Response to Highways England Deadline 6 Documents 8.68, 8.69 & 8.73:

8.68 Applicant's Responses to Examining Authority's Third Round of Written Questions

8.69 Post Hearing submissions – Written summary of Oral Case for the ISH on Living Conditions on 1 October 2019

8.73 Applicant's Responses to Actions in respect of ISH on Compulsory Acquisition on 20 August 2019

Drawing Number HE551485	Highways England PIN -ACM	Originator -HML	Volume -SK-CH-0002	Rev P01
M42_ML_01_ZZ	-SK-CH-0002			
Location	Type	Role	Number

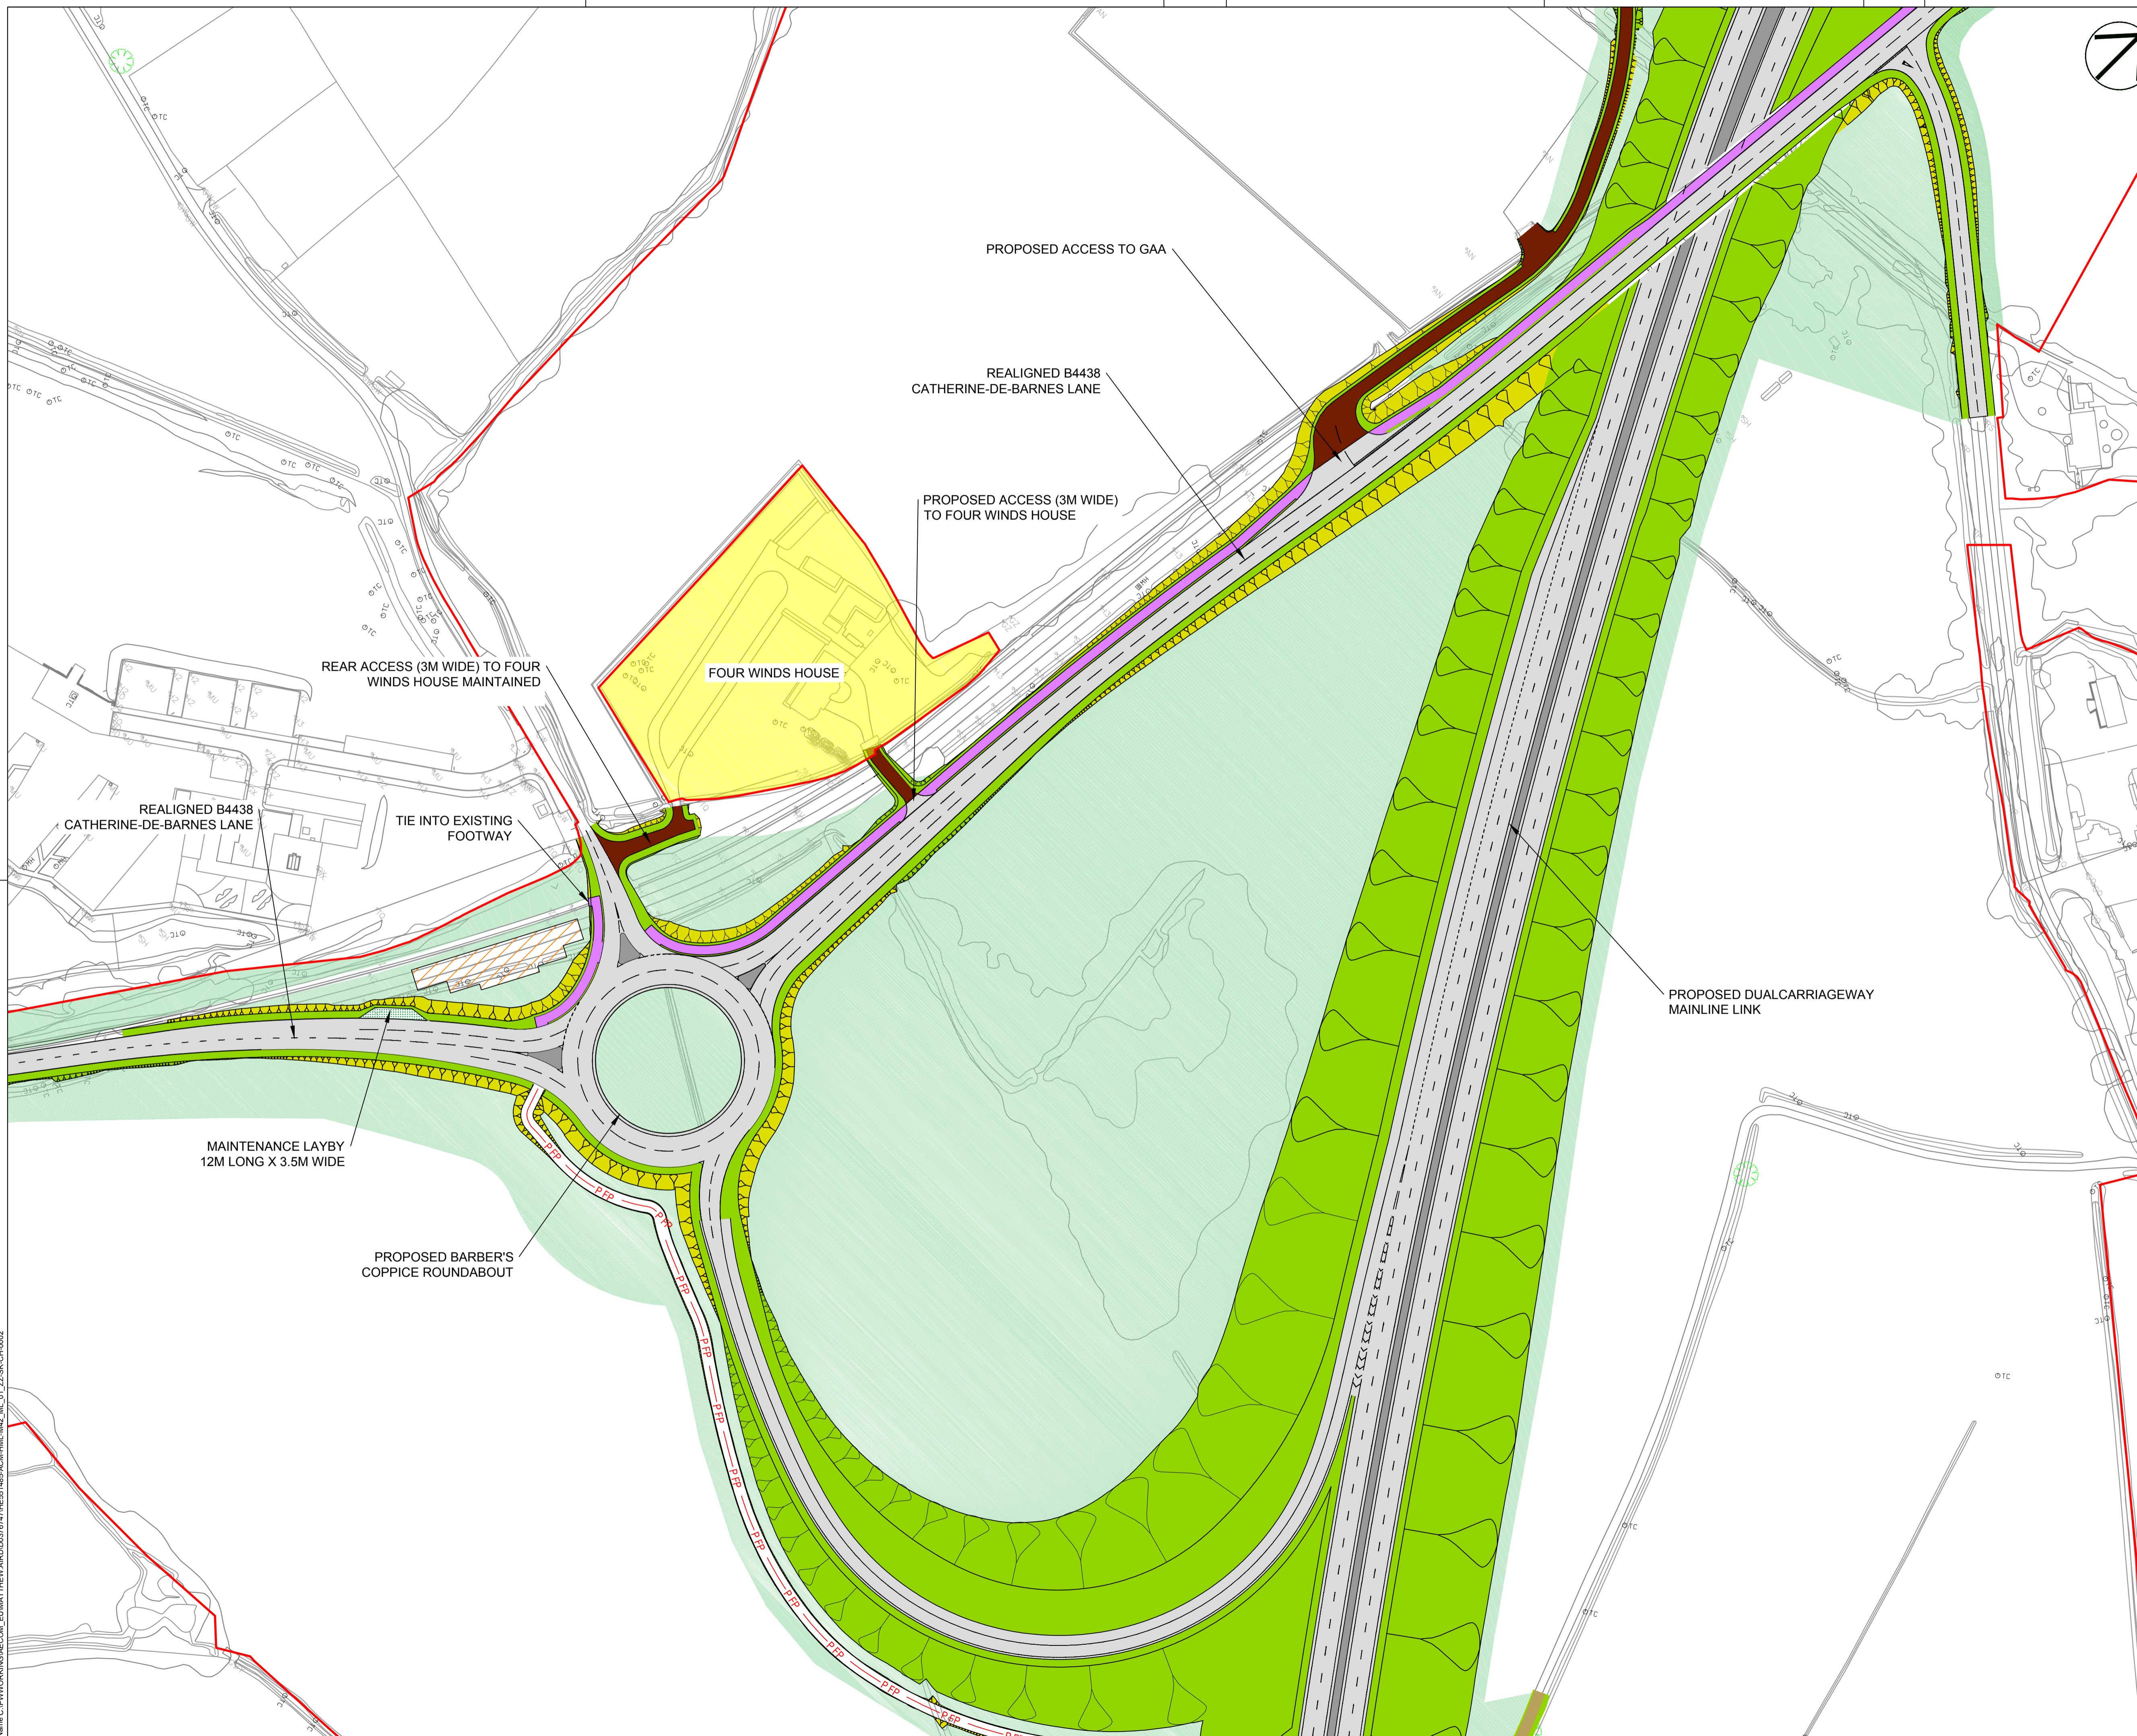
In HE document '8.23 Lighting Technical Note' the length of 'Barber's Coppice Roundabout' is stated as 740m and the length of 'Bickenhill Roundabout' is stated as 330m.

The Merge Slip from 'Barber's Coppice Roundabout' to proposed Mainline link is not an approach road to 'Barber's Coppice Roundabout'.

The two approach roads to 'Barber's Coppice Roundabout' are therefore the 40mph section of southbound carriageway of the realigned Catherine de Barnes Lane and the 50mph section of northbound carriageway of the realigned Catherine de Barnes Lane.

'Bickenhill Roundabout' is approached from four roads - the 70mph slip road from the proposed Mainline Link, the 30mph section of southbound carriageway and the 40mph section of northbound carriageway of the realigned Catherine de Barnes Lane, and the 30mph approach from St. Peters Lane. Somehow, the length of 'Bickenhill Roundabout' has been calculated to be 330m, less than half the stated 740m length of 'Barber's Coppice Roundabout'.

Unfortunately, the distances shown on the drawing are incorrect.

'Barber's Coppice Roundabout' has a circumference of 220m, taken from AutoCAD drawing provided by HE - 'HE551485-ACM-HML-M42_ML_01_ZZ-SK-CH-0002'. It is not 240m as shown.

The Merge Slip from 'Barber's Coppice Roundabout' to proposed Mainline link is not an approach road to 'Barber's Coppice Roundabout'. 160m has therefore been included in error.

The northern approach road to 'Barber's Coppice Roundabout' has a speed limit of 40mph. The desirable minimum stopping sight distance is therefore 120m. It is not 160m as shown.

The southern approach road to 'Barber's Coppice Roundabout' has a speed limit of 50mph. The desirable minimum stopping sight distance is therefore 160m, as shown on the HE drawing.

∴ The length of 'Barber's Coppice Roundabout' is 220m + 120m + 160m + 20m = **520m (NOT 740m)**

'Bickenhill Roundabout' has a circumference of 180m, taken from AutoCAD drawing provided by HE - 'HE551485-ACM-HML-M42_ML_01_ZZ-SK-CH-0002'.

The 'Diverge Slip from proposed Mainline link to Bickenhill Roundabout' has a speed limit of 70mph (113kph). The design speed is rounded up to 120kph resulting in a desirable minimum stopping sight distance of 295m.

The southern approach road to 'Bickenhill Roundabout' has a speed limit of 40mph. The desirable minimum stopping sight distance is 120m.

The northern approach road to 'Bickenhill Roundabout' has a speed limit of 30mph. The desirable minimum stopping sight distance is 90m.

The eastern approach road (St. Peters Lane) to 'Bickenhill Roundabout' has a speed limit of 30mph. The desirable minimum stopping sight distance is 90m.

∴ The length of 'Bickenhill Roundabout' is 180m + 295m + 120m + 90m + 90m = **775m (NOT 330m)**

Given the above, it is difficult to conclude that HE can justify any lighting provision to the 'Barber's Coppice Roundabout' (or its approach roads).
